Application no: H08/0023/09

Description: Repairs and renovations to dwelling

Location: 'Chespool House' Chesboule Lane
Gosberton Risegate

Amendment: Omitted 2 windows and removed internal temporary wall
(dwg. no. 1070-03)

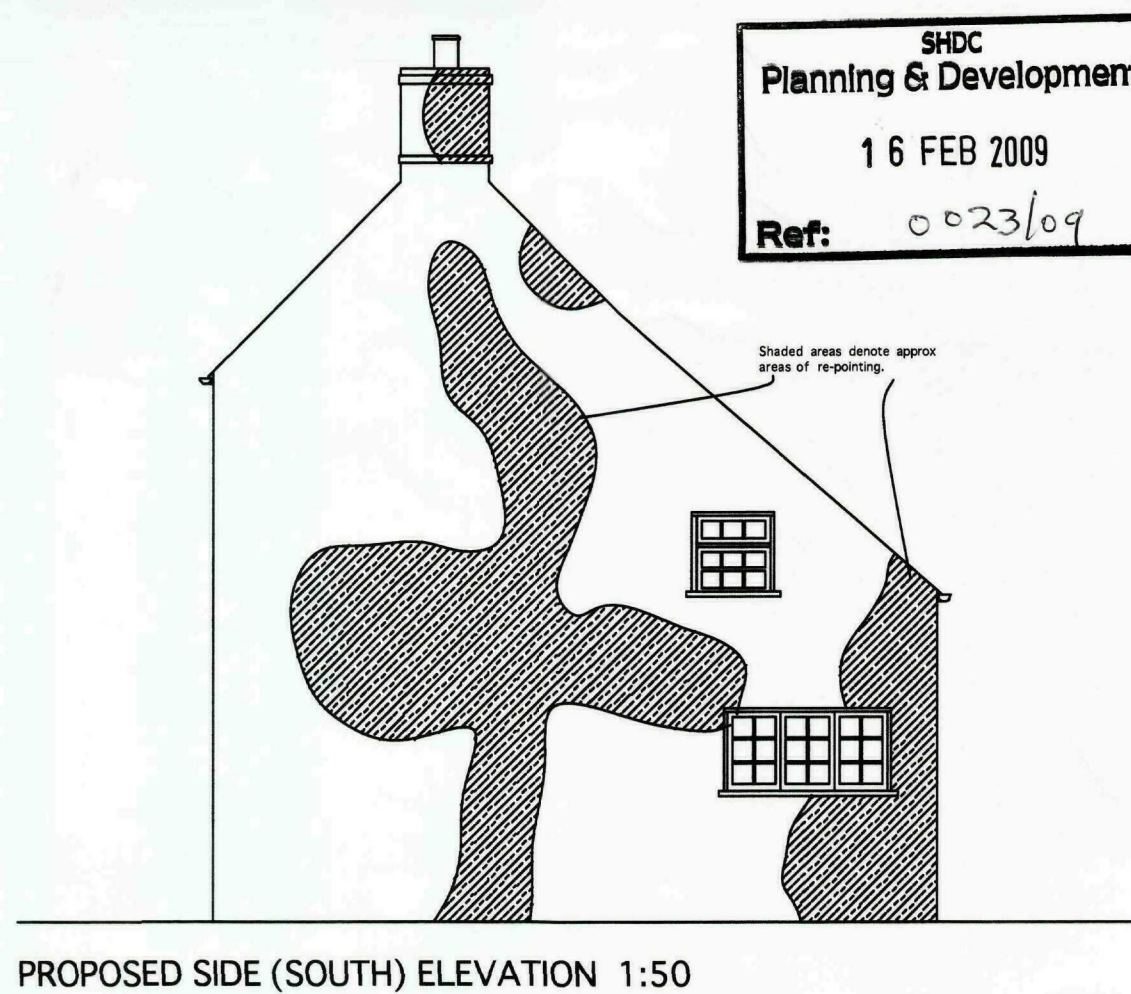
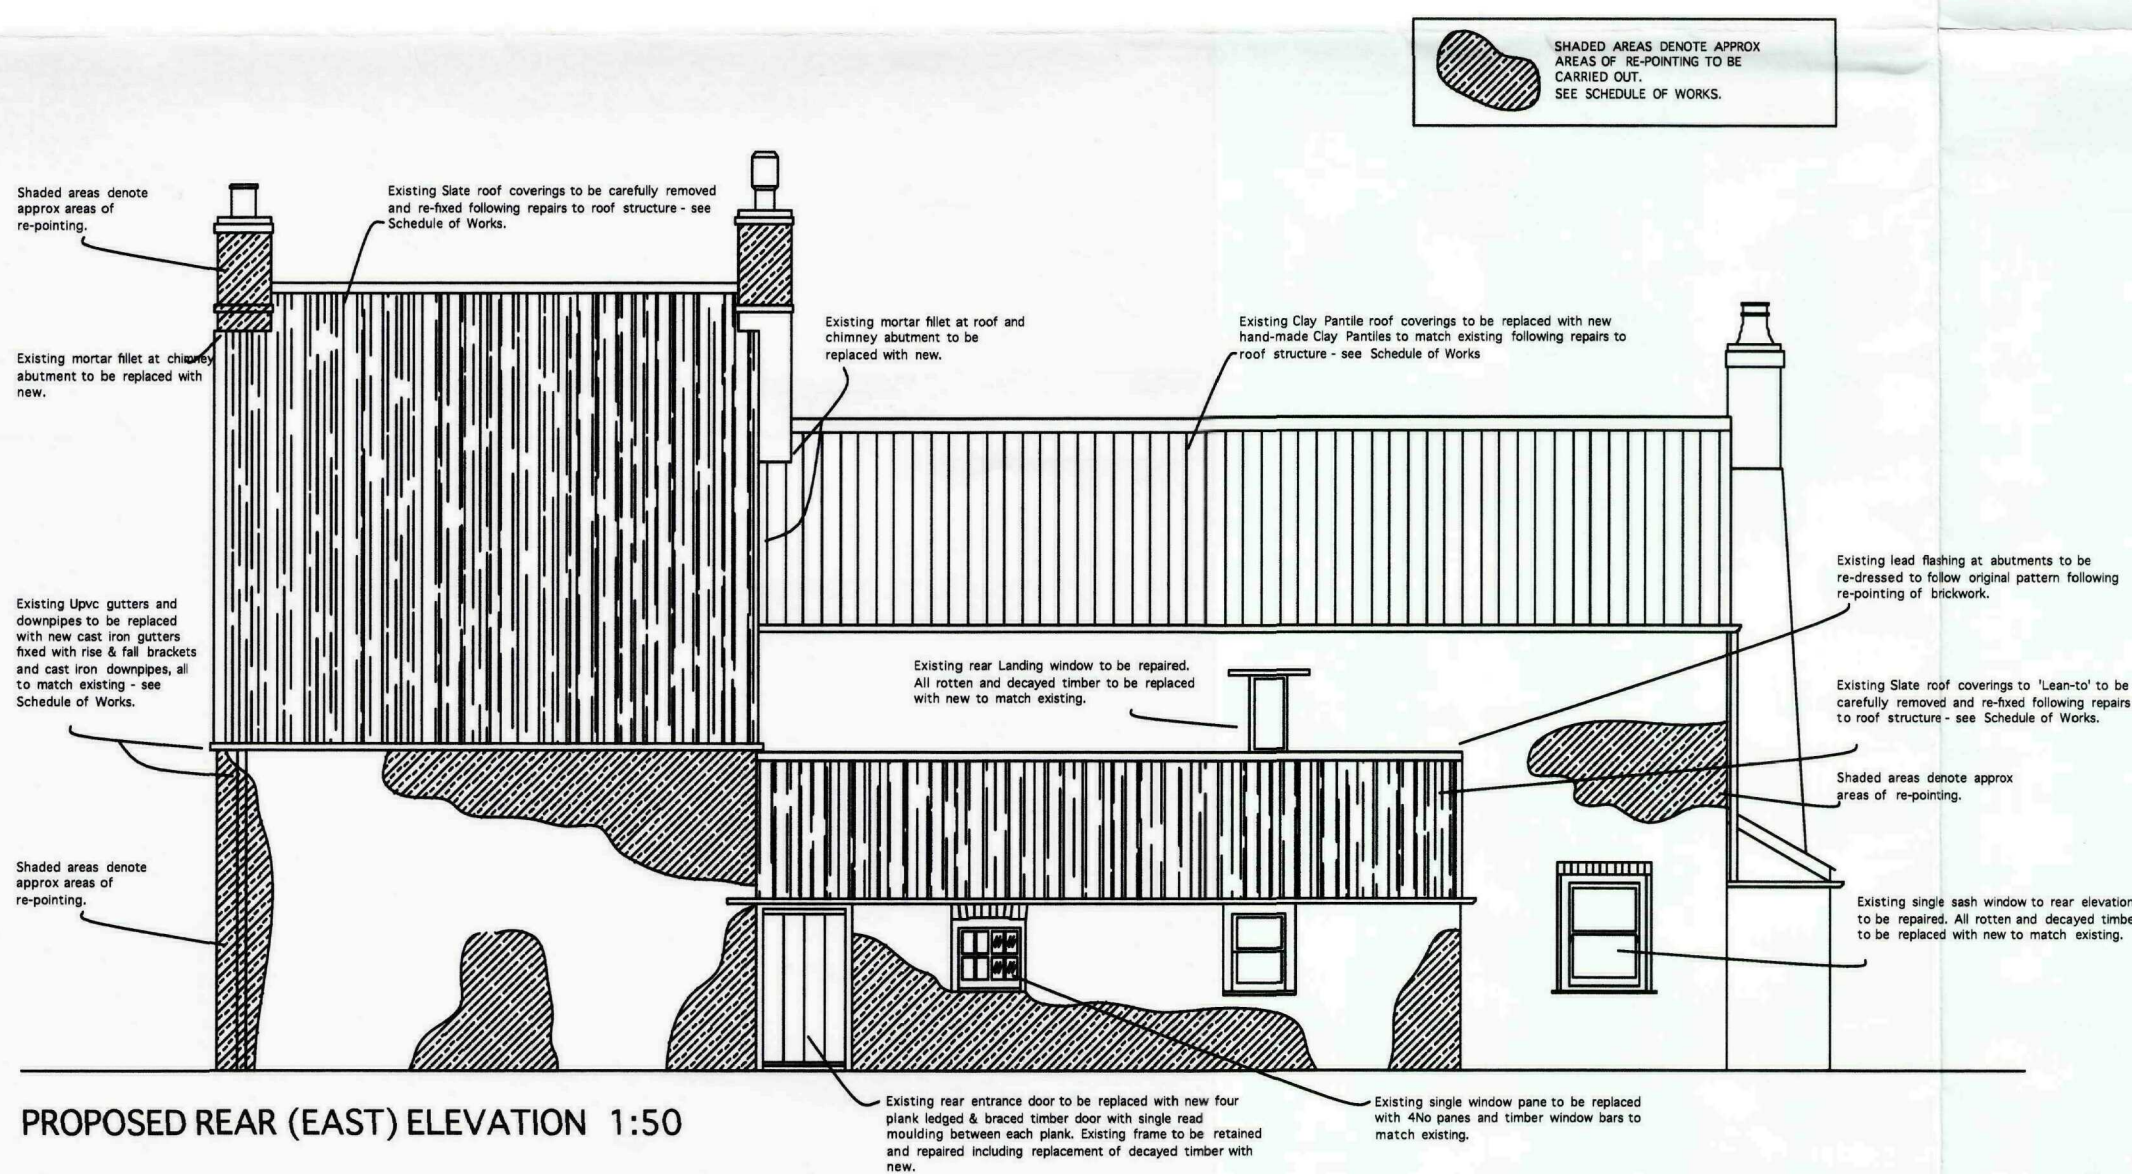
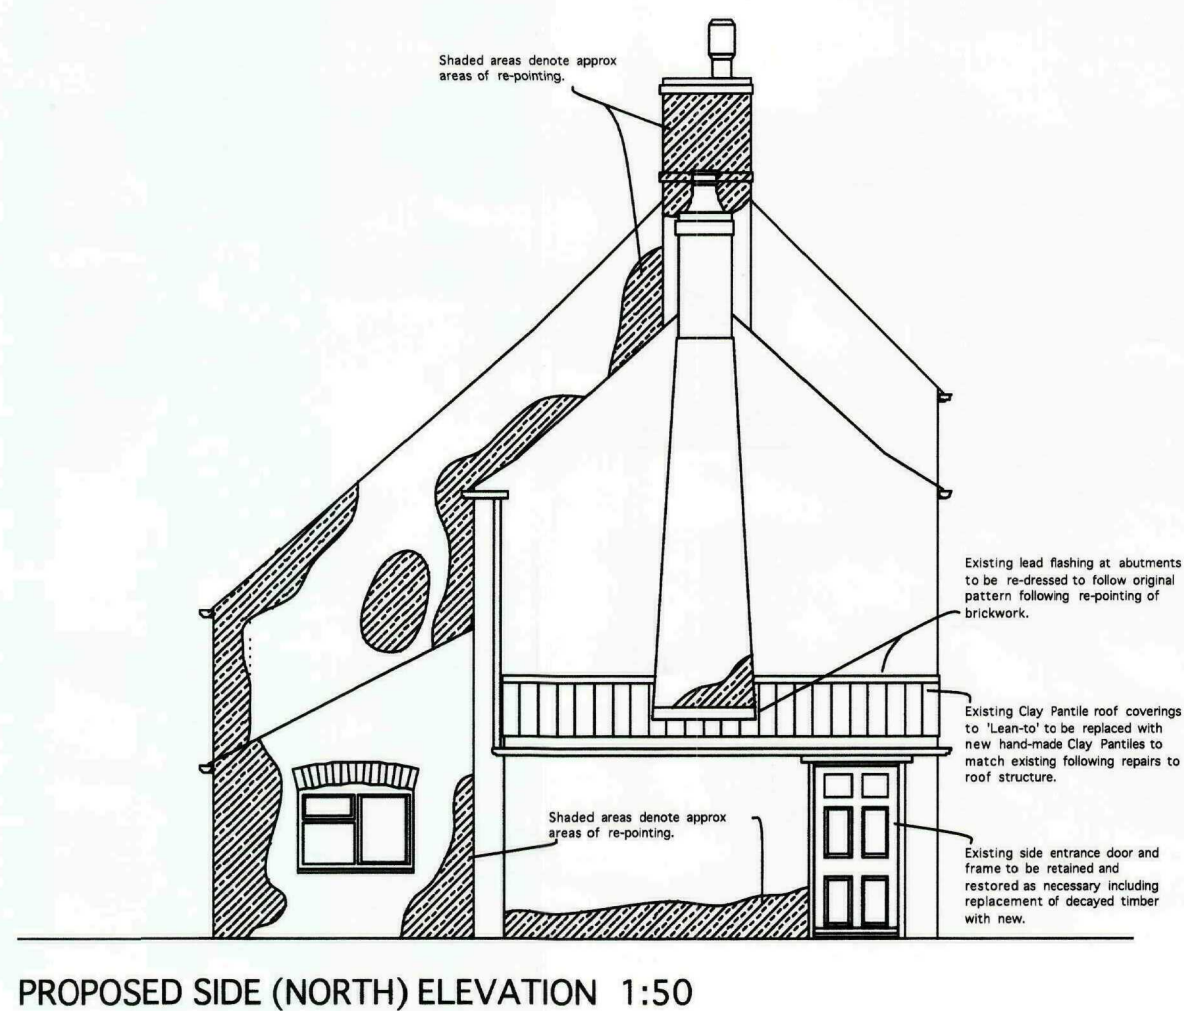
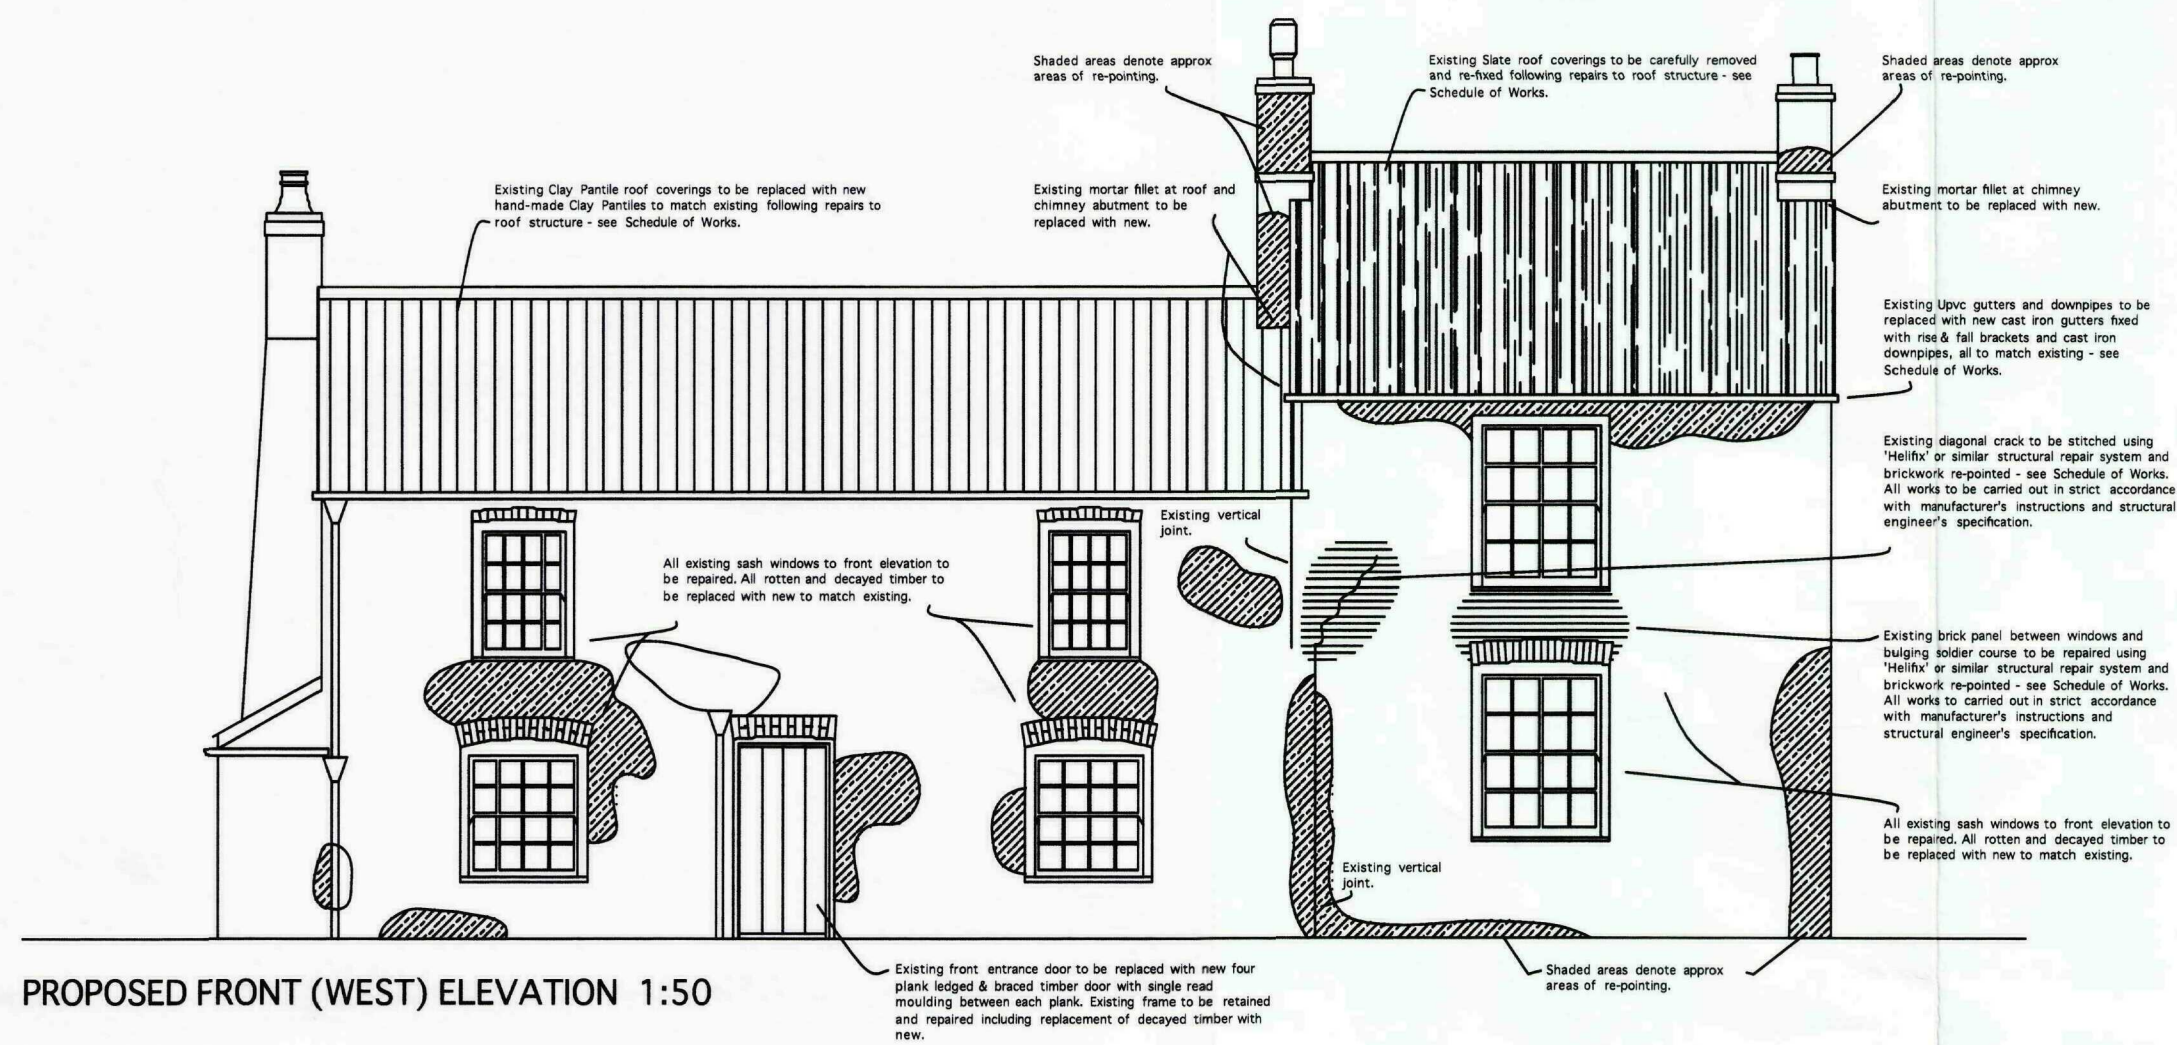
As discussed please find amended proposed elevations and floorplans for your records, I have removed from the drawing the two modern windows we discussed removing on site. I have also removed the temporary wall dividing the rear hall/lobby in two.
